**Esso Banbury Service Station Oxford Road
Bodicote OX15 4AB**

20/02498/F

Recommendation: Refuse

Proposal: Single storey rear extension

Proposed Floor Plan

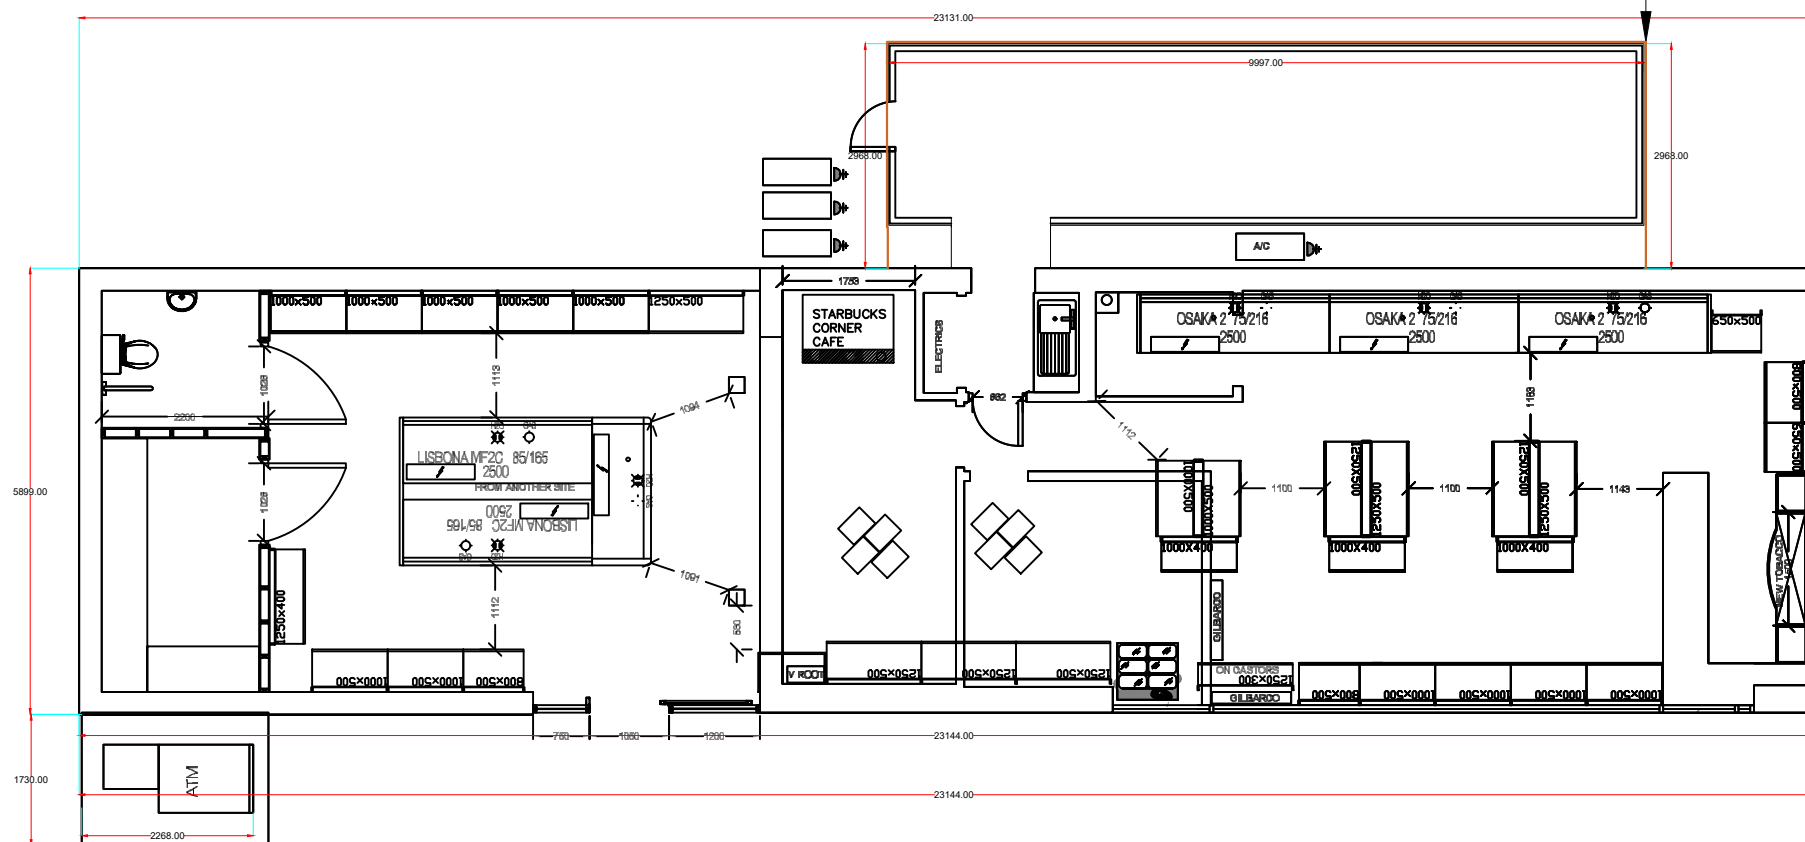
8.6. Whilst the materials of the container would now be altered to match that of the main kiosk building, the utilitarian form would remain. The building would continue to lack openings or detailing and would remain a bland and unattractive structure. Its connection to the main kiosk building would be limited, would still have the same height difference and would be sited in the same location and proximity to the kiosk building. Thus, the building would retain the disjointed and cluttered appearance previously deemed unacceptable by the Planning Inspector. Officers note the comments of the parish council who come to the same conclusion.

Proposed Elevations

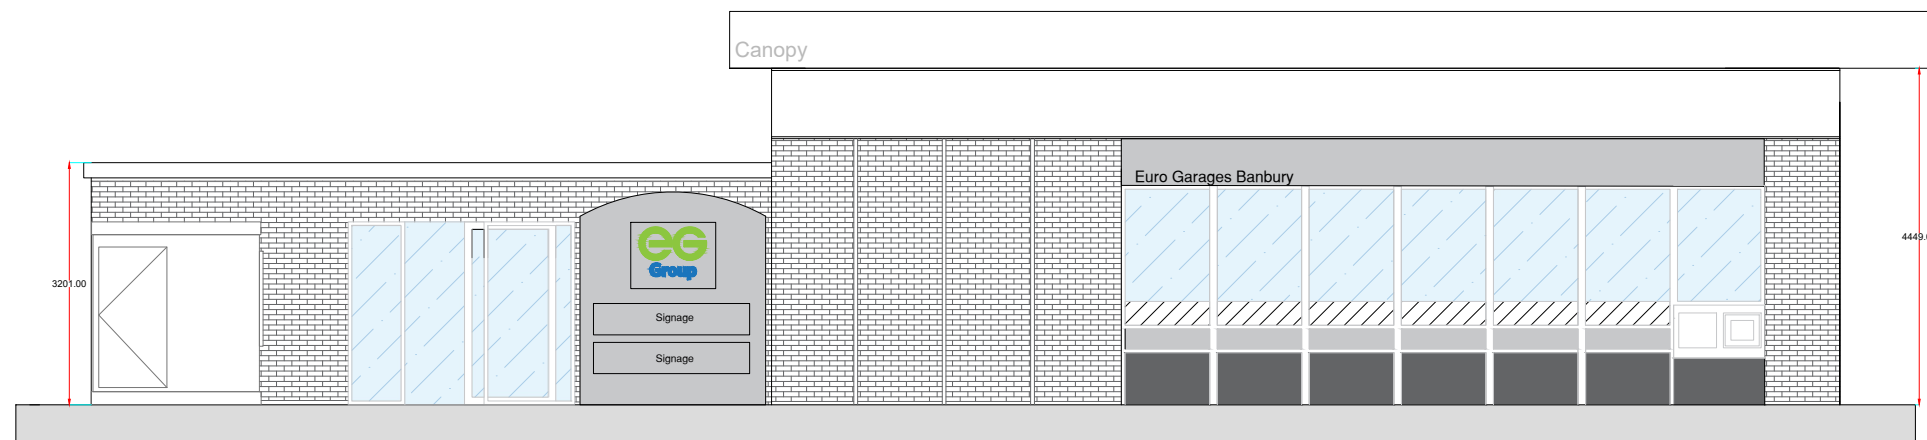
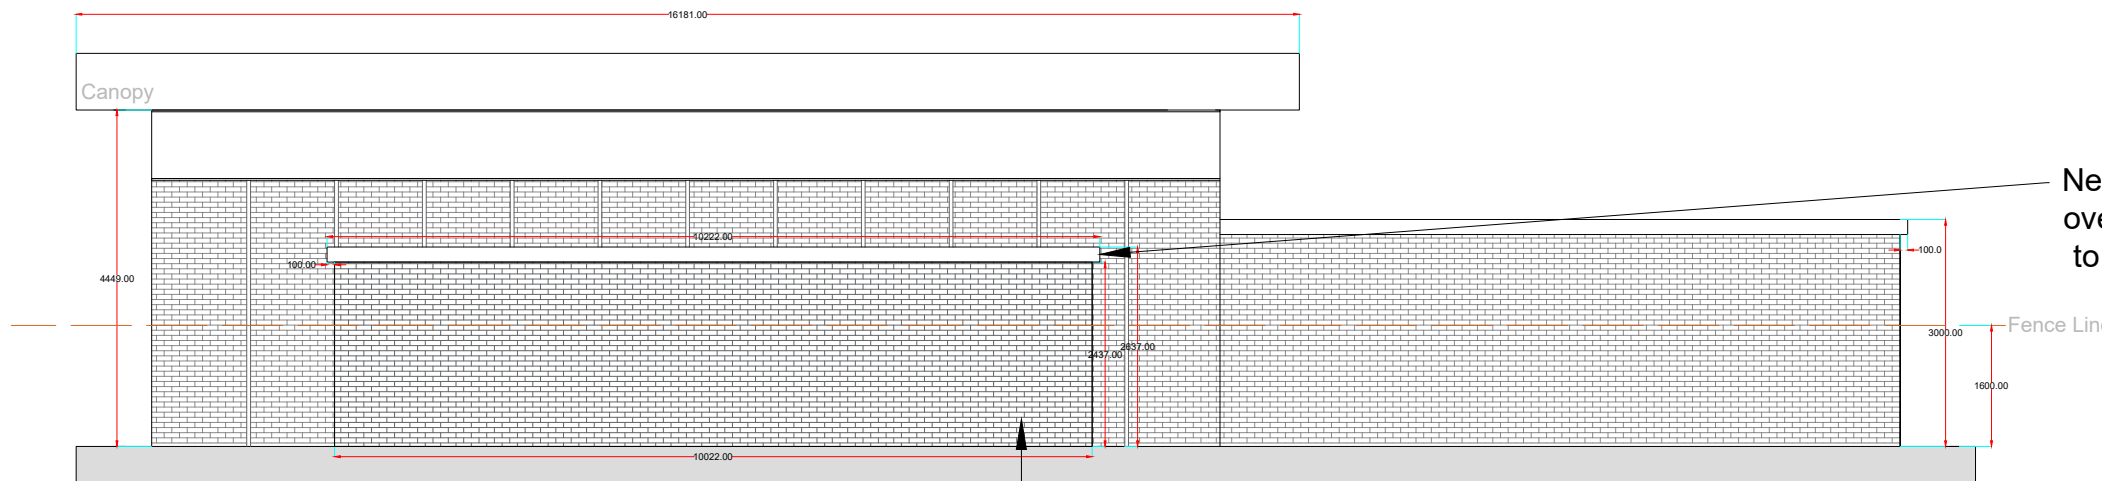
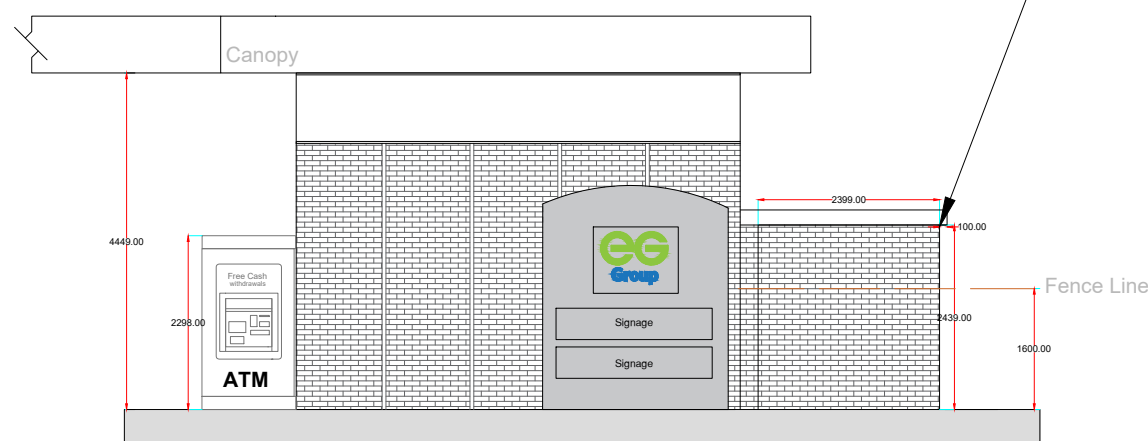
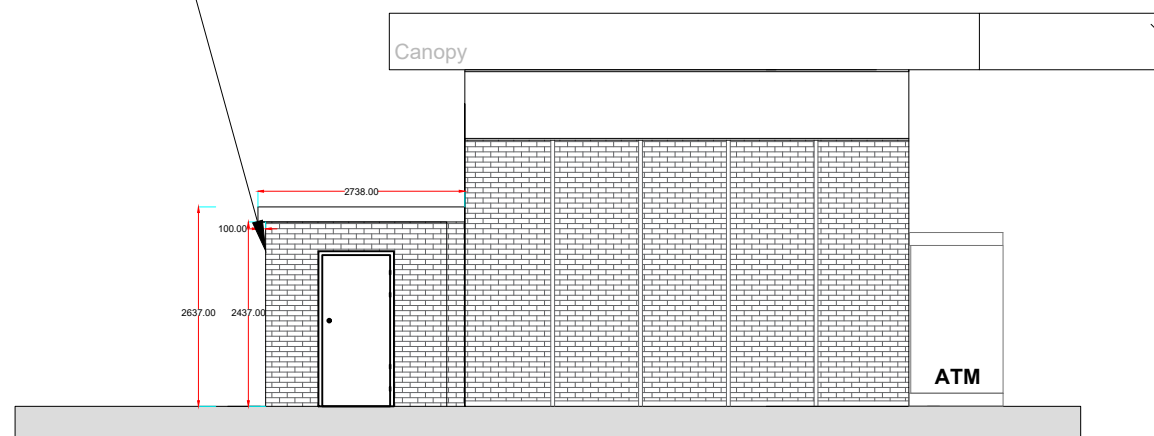
1. By virtue of its utilitarian design and its siting, height and proximity to the main kiosk building and without sufficient justification for the discounting of alternative, less harmful options, the existing shipping container being clad in brick would result in harm to the character and appearance of the area. The proposed development is therefore contrary to Policy ESD15 of the Cherwell Local Plan 2011-2031 and saved Policy C28 of the Cherwell Local Plan 1996 and relevant paragraphs of the National Planning Policy Framework.
